Engineers Comments Regarding Surface Water Drainage

Application Reference:	BN/76/26/DOC	Reviewer Reference:	ADC/EXT2/113
Planning Officer:	Amber Willard	Date of Review:	07/09/2026
Site Name:	Land South Of Wandleys Lane Eastergate PO20 3SE		
Application Description:	Approval of details reserved by condition under BN/46/25/PL relating to conditions 4- Surface Water Drainage and 9- Maintenance & Management of Sustainable Drainage Scheme.		
Assessment Number:	2

Date	09.02.26	Scale	1:10 @ A1	Dwg. No.	476988/912 P03
Drawn	SWF	Chk'd	TB	QA'd	TB

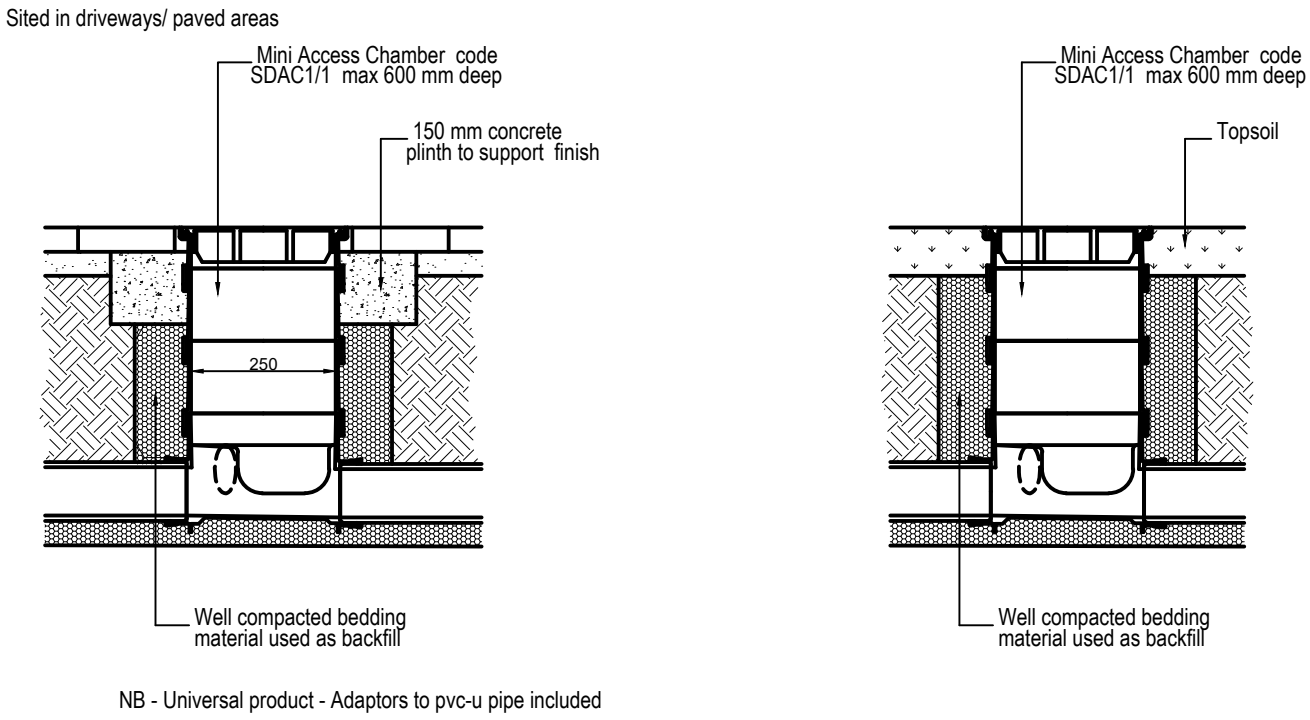
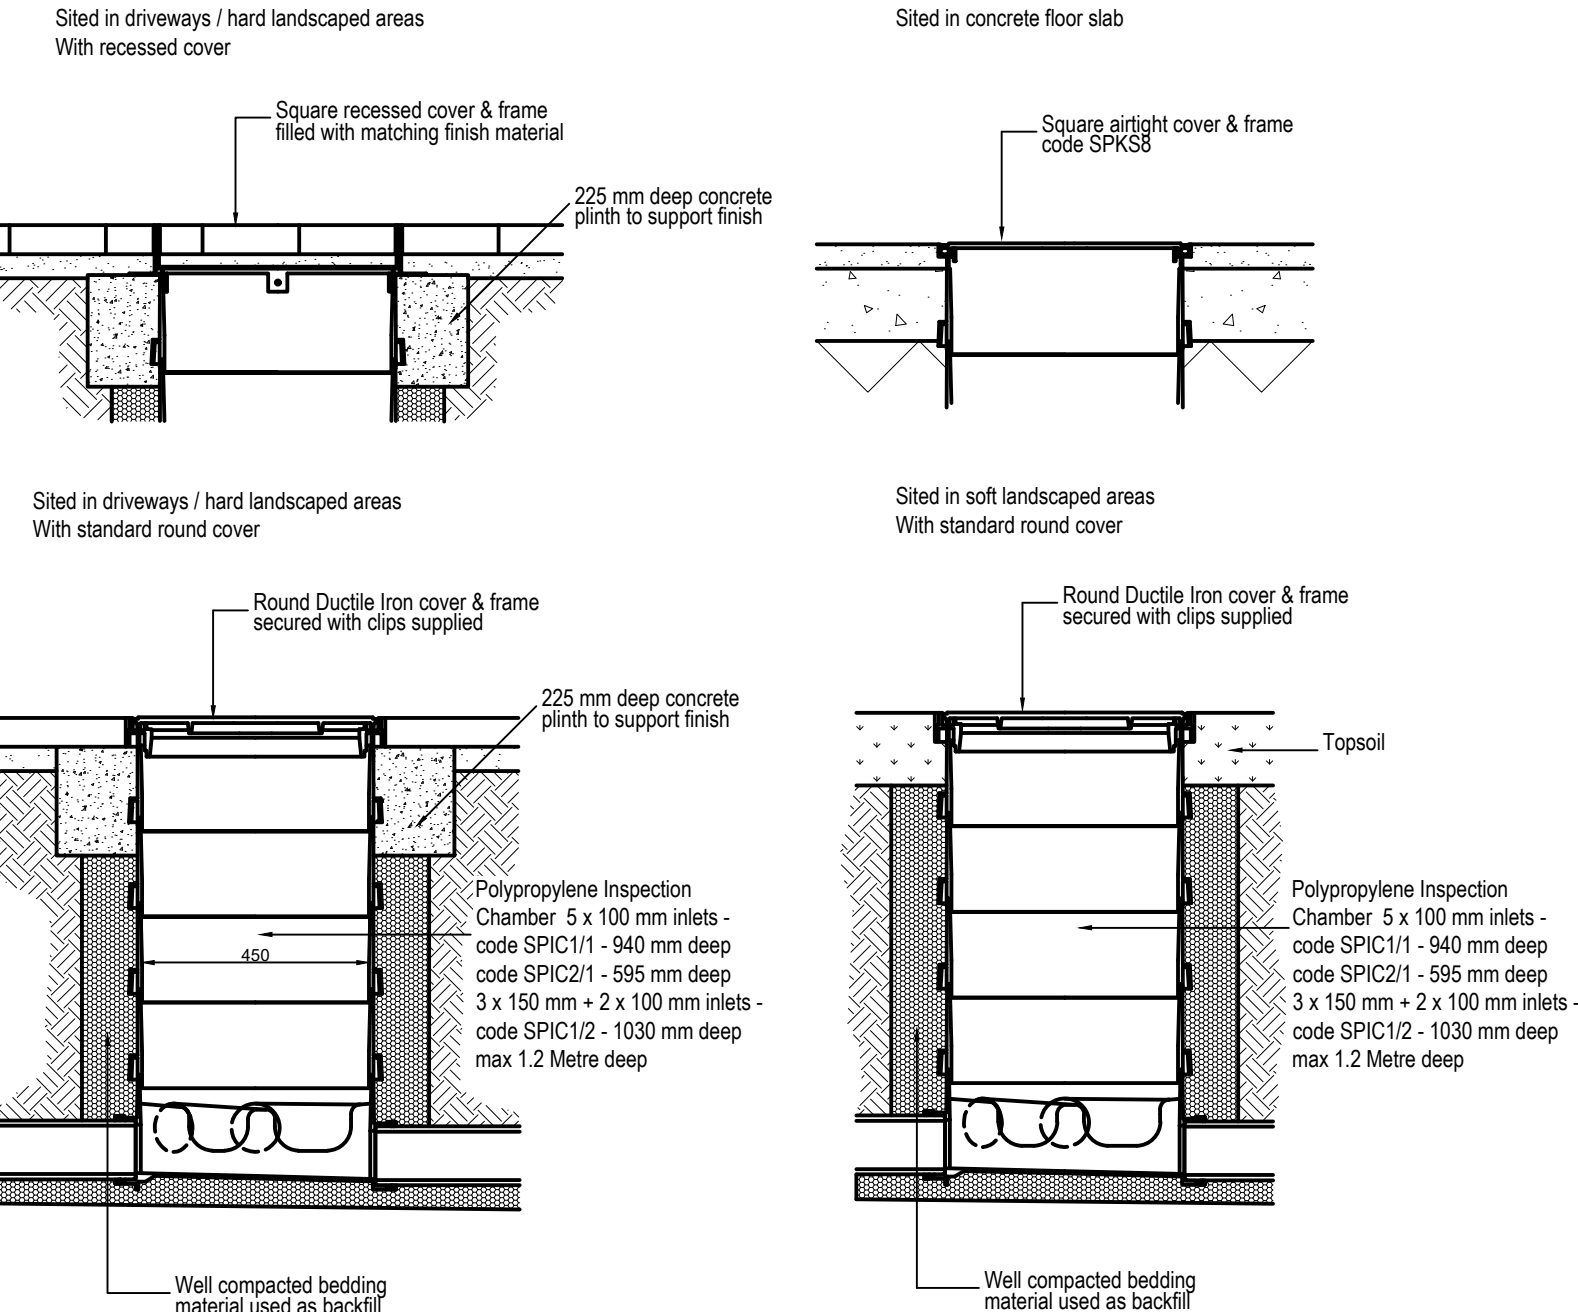
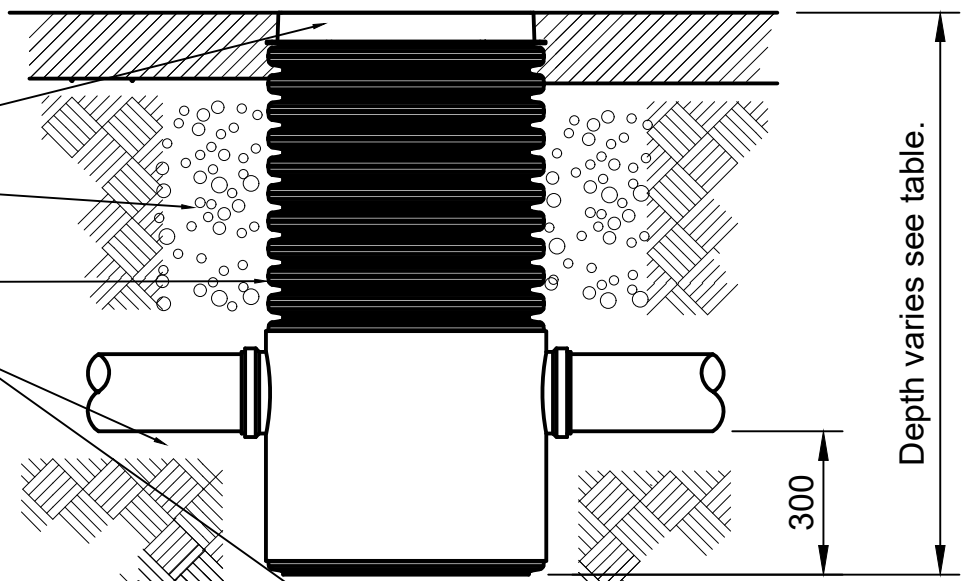
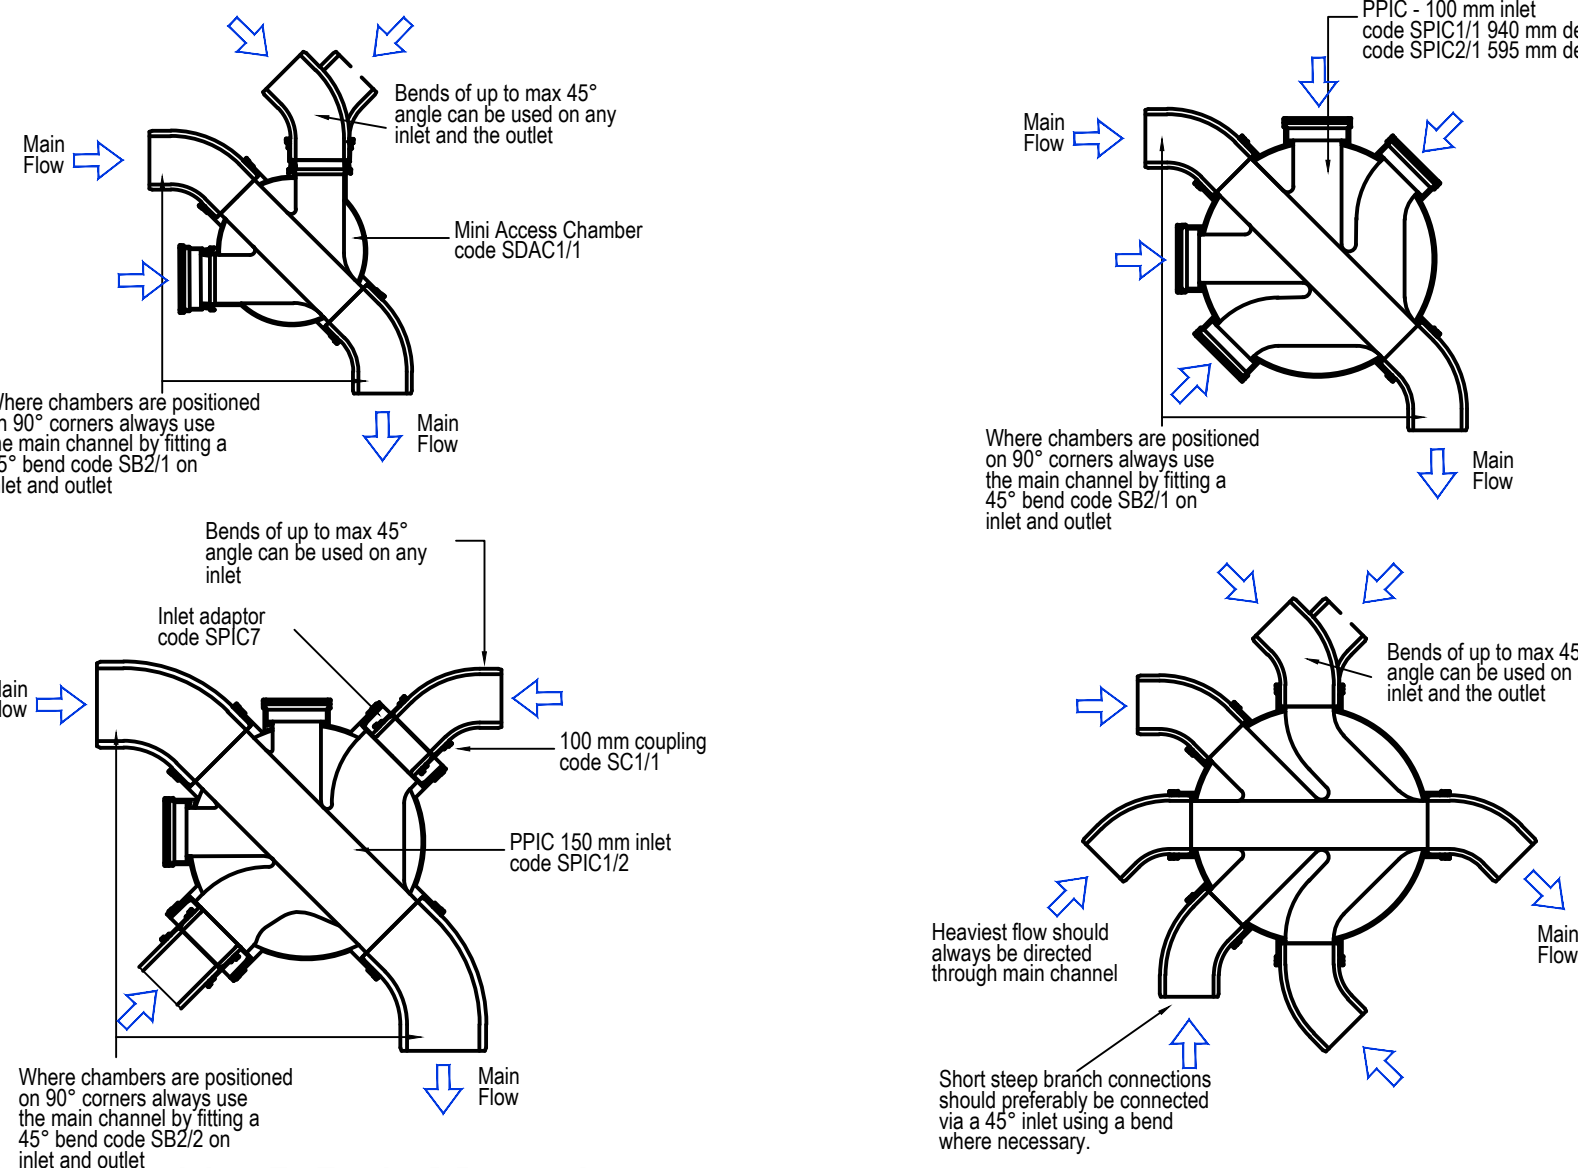
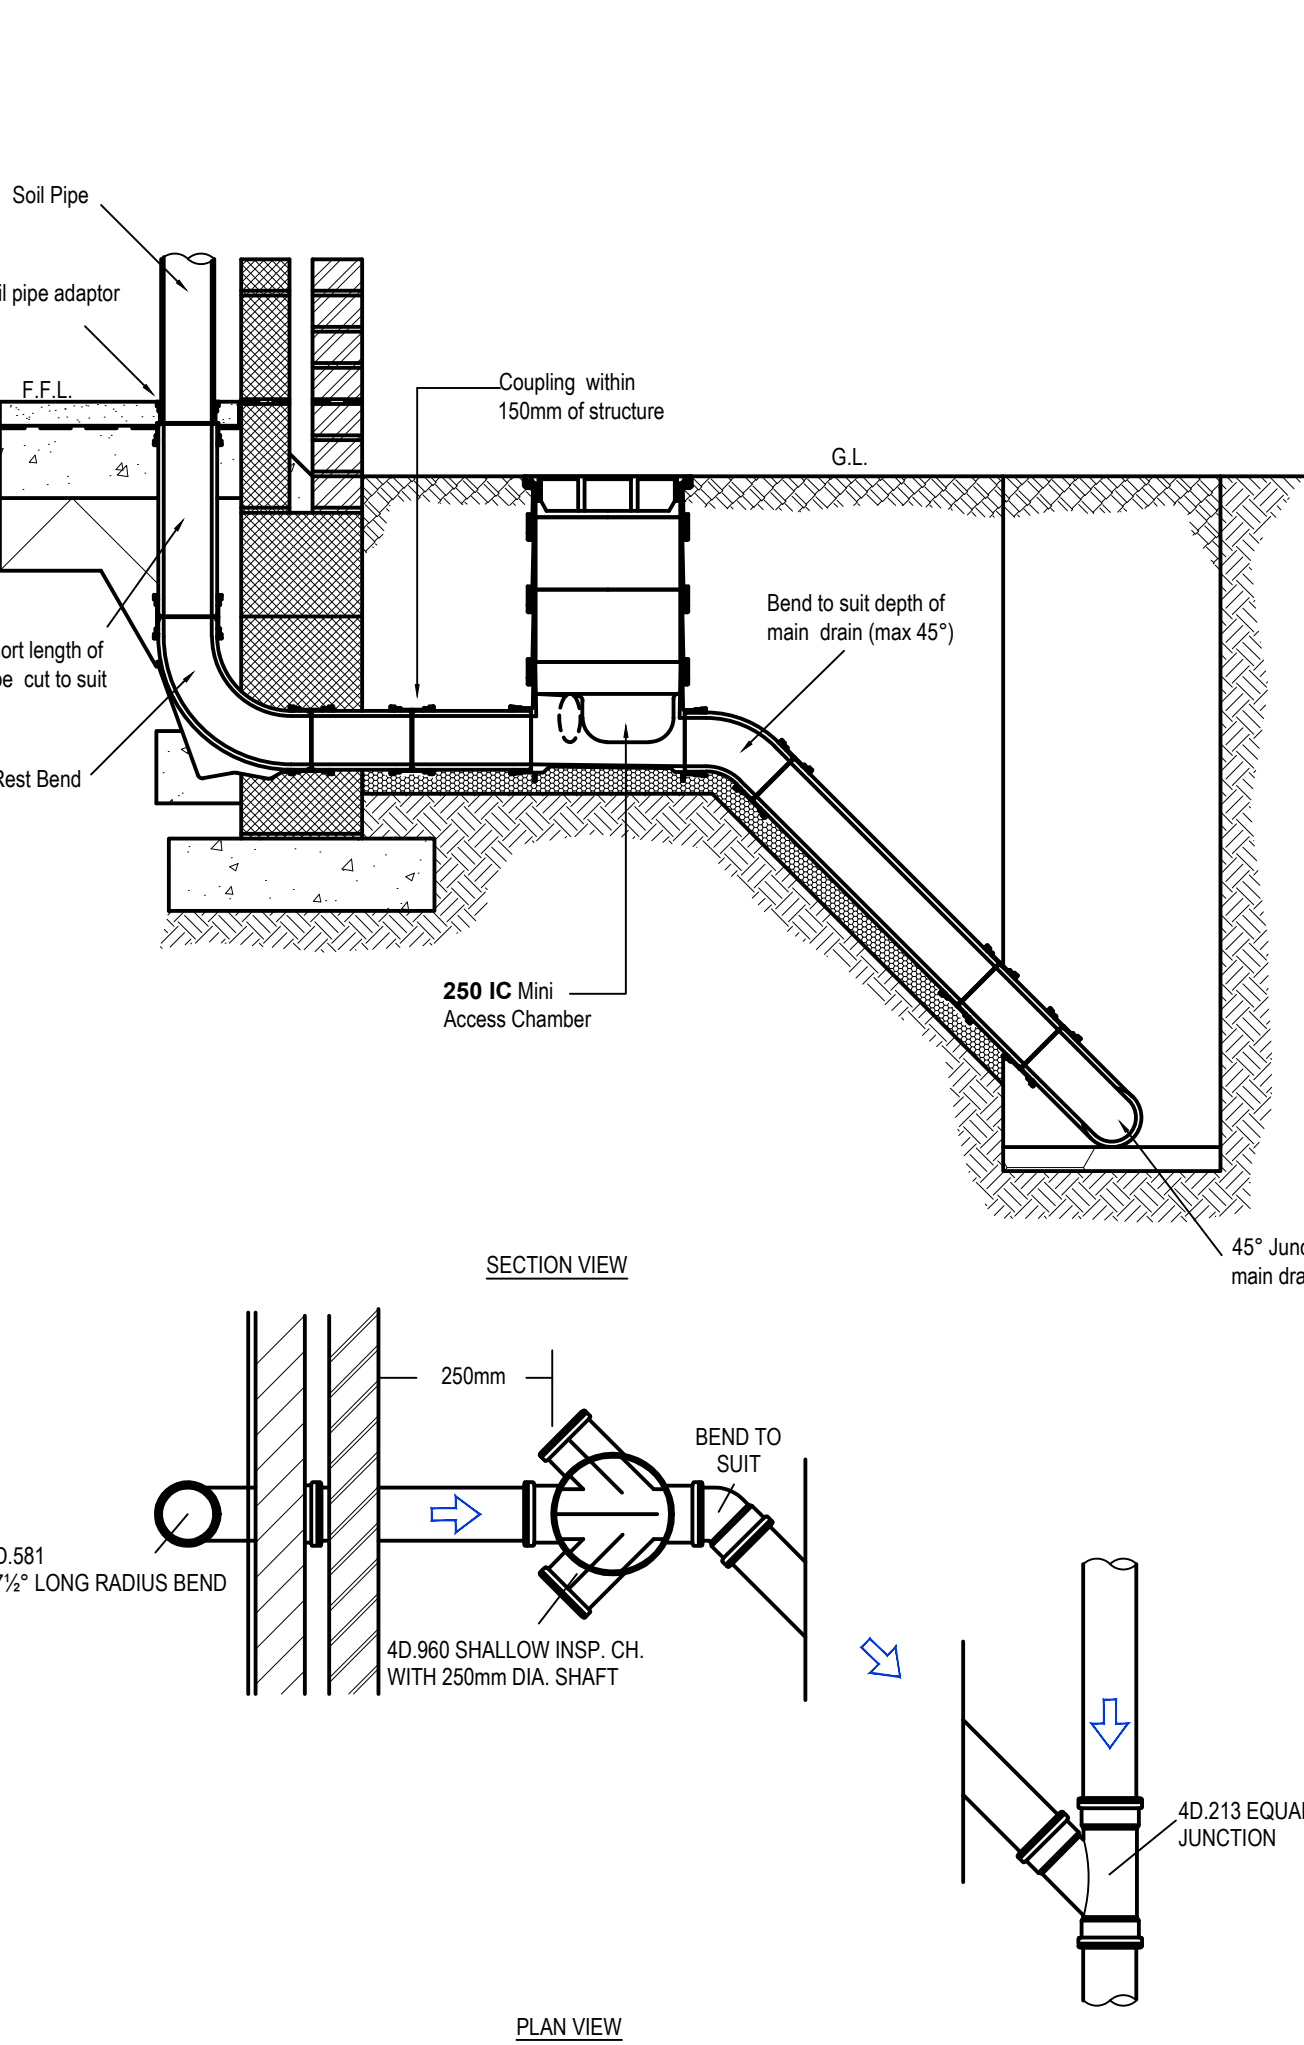
16.	Construction detail updated. Please refer to drg no. 476988-912_P03 – Construction Details-- Sheet 2.			Noted.	
17.	Our initial response was incorrect. There are several road gullies within the drainage designs.	Noted. Comment closed.

29.	Inspection chamber types have been added to the construction details. Please refer to drg no. 476988-912_P03 – Construction Details-- Sheet 2.	Noted. Comment closed.
